WEST SUSSEX COUNTY COUNCIL CONSULTATION

TO:	Arun District Council FAO: David Spring
FROM:	WSCC - Highways Authority
DATE:	1 May 2020
LOCATION:	Rear of Rookery Farm 113 North Bersted Street Bersted PO22 9AG
SUBJECT:	BE/16/20/PL Demolition of storage buildings & erection of 1 No 3-bed cottage. This application affects the setting of listed buildings & affects the character & appearance of the North Bersted Conservation Area. More information received.
DATE OF SITE VISIT:	n/a
RECOMMENDATION:	Advice
S106 CONTRIBUTION TOTAL:	n/a

Drawing 3A - Proposed Site Plan

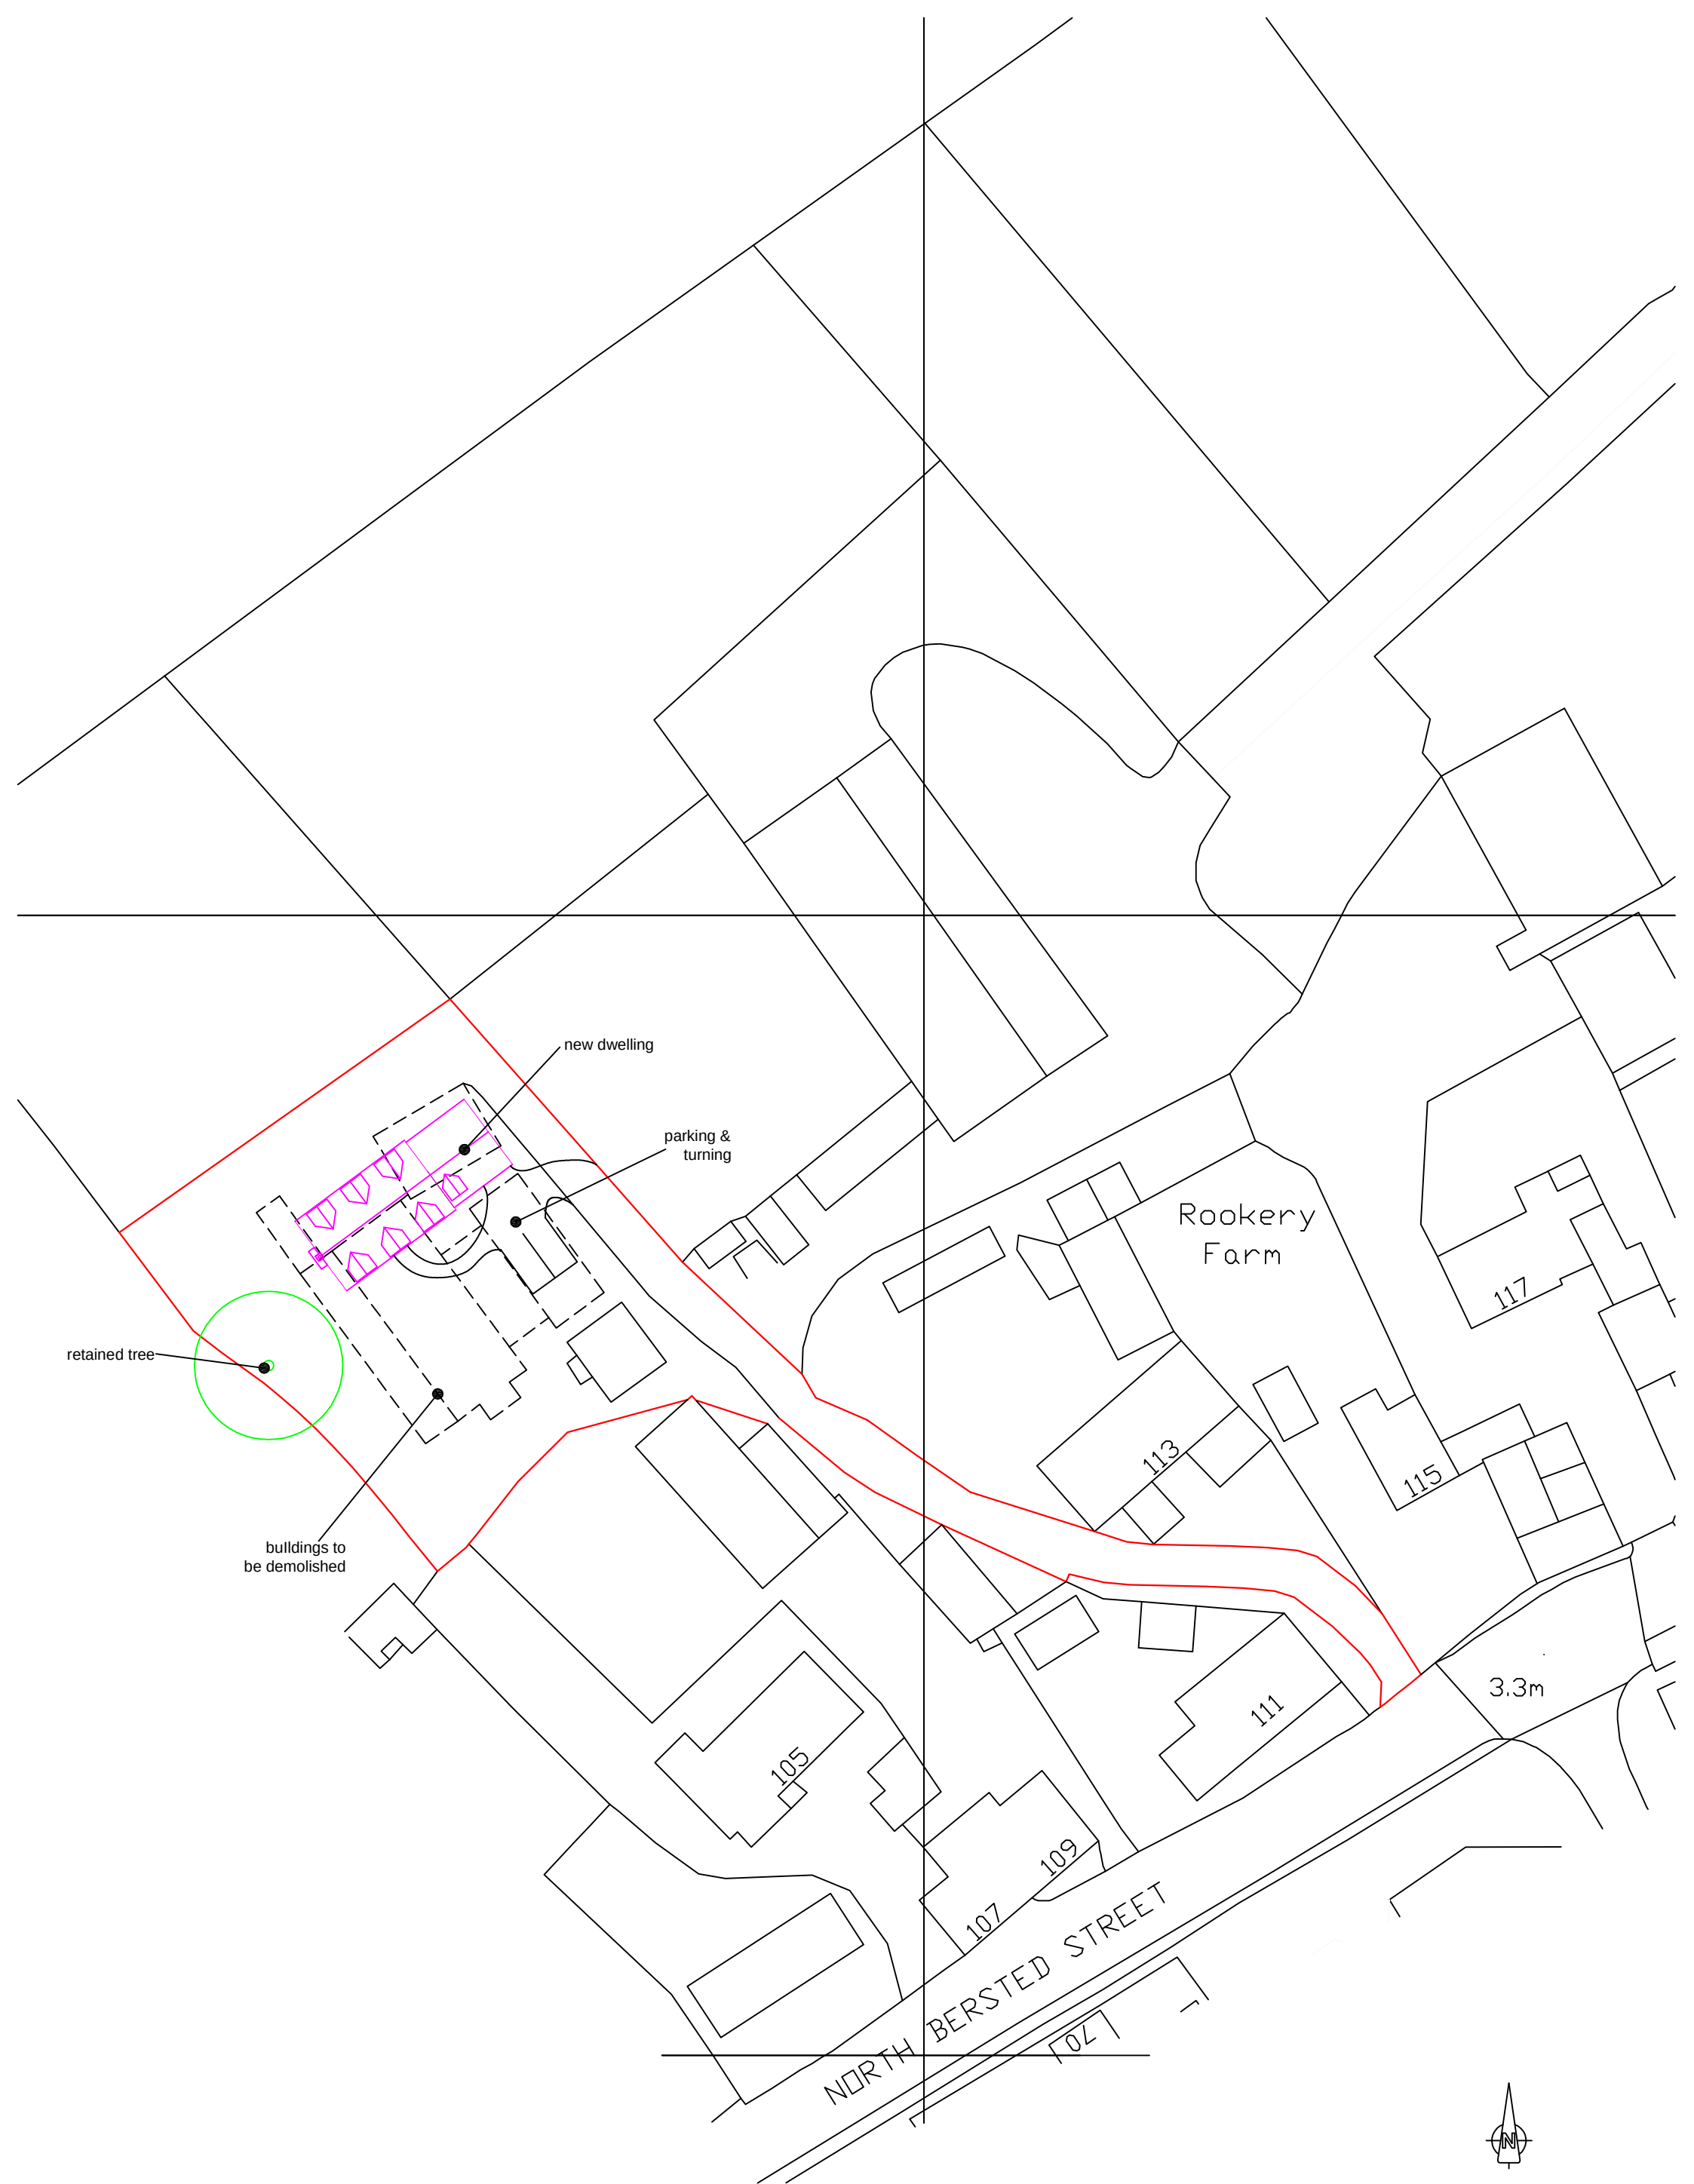
The applicant has demonstrated two parking spaces each measuring 2.4 x 4.8 metres in accordance with Arun parking standards.

The applicant has demonstrated a turning area 4.5 x 6 metres this conforms to WSCC guidance of 6 metres at 90 degrees to all parking spaces.

The applicant has stated in an email that cycle parking will be located within the garage. This conforms to Arun parking standards.

To summarise the LHA raises no concerns over the Parking or Turning.

No part of the development shall be first occupied until the car parking has been constructed in accordance with the approved site plan. These spaces shall thereafter be retained at all times for their designated purpose.

No part of the development shall be first occupied until covered and secure cycle parking spaces have been provided in accordance with the approved site plan.

No part of the development shall be first occupied until the vehicle turning space has been constructed within the site in accordance with the approved site plan. This space shall thereafter be retained at all times for their designated use.
